**Application no: 22/03397/DISC**

**Location:** Land To The South And Adj To, South Side, Steeple Aston

## **Lead Local Flood Authority**

Condition 6 states:

SECTION THROUGH 4.5m PERMEABLE BLOCK PAVED ACCESS & PERMEABLE BLOCK PAVED DRIVEWAY
Scale 1:20

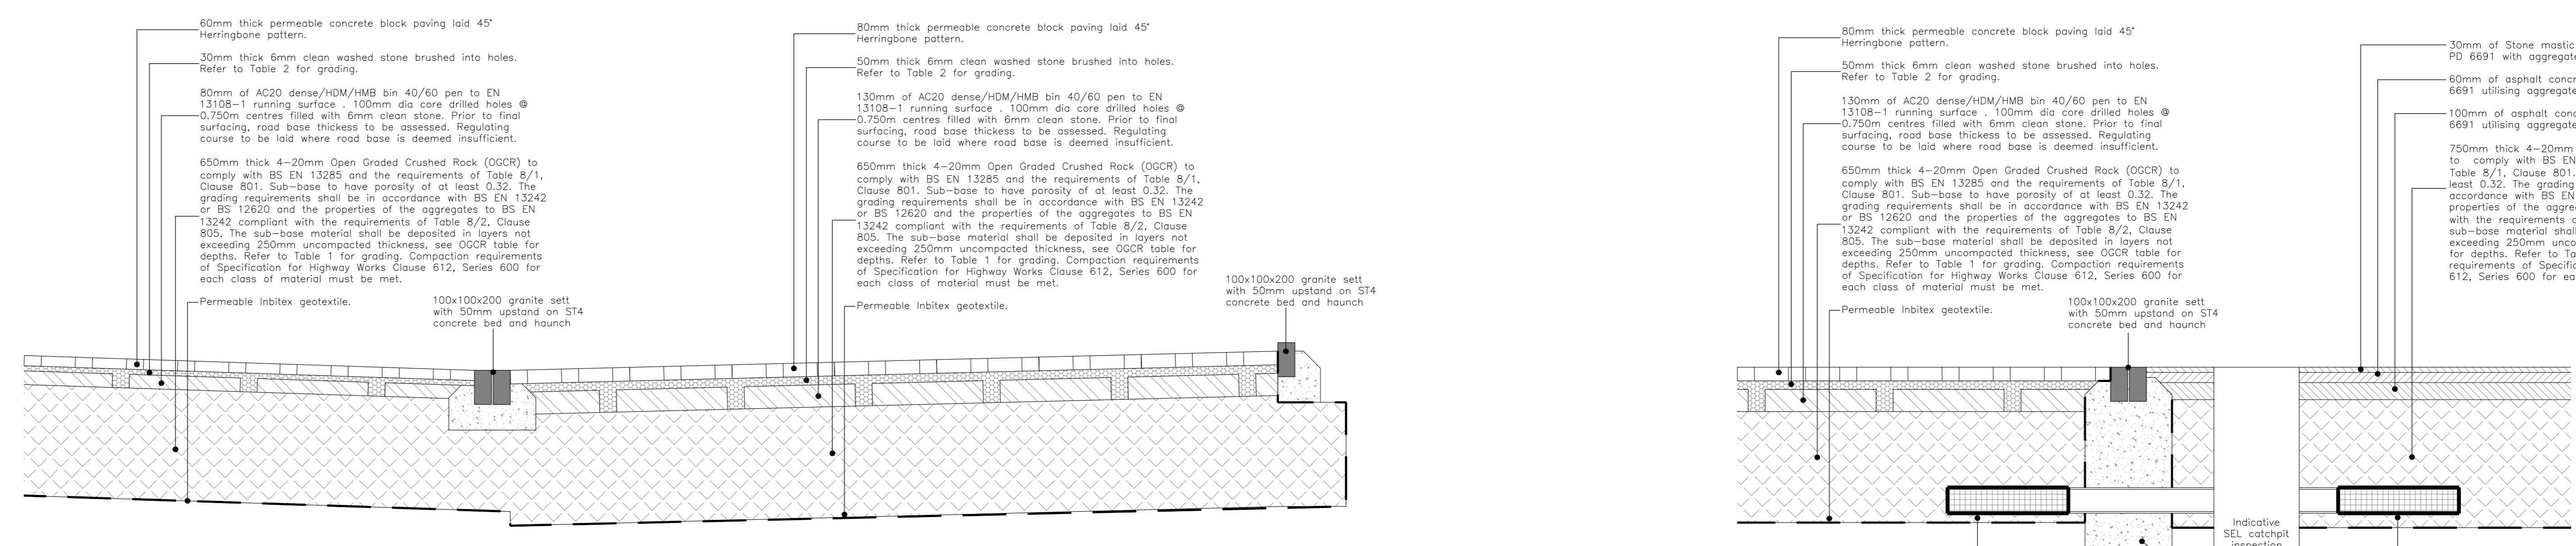
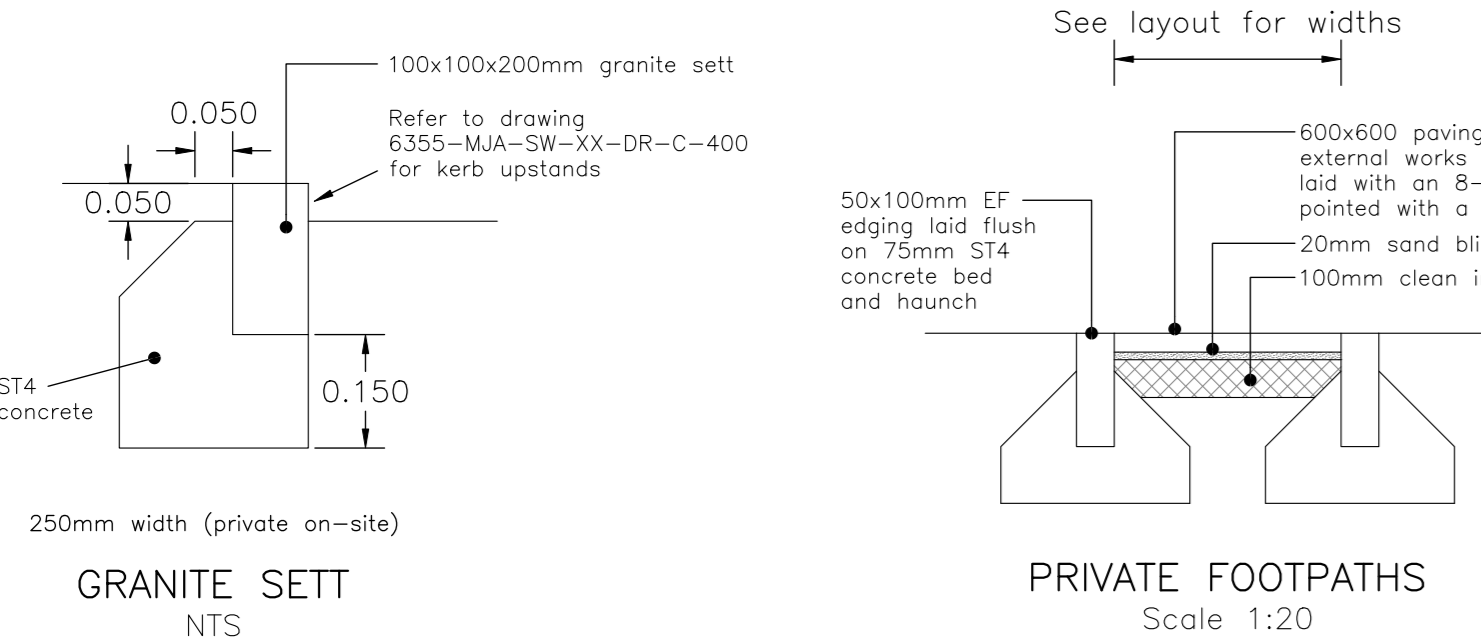
**Photographs provided relates to foul drainage. This condition refers to SuDS elements and surface water infrastructure. Laying of permeable paving not provided.**
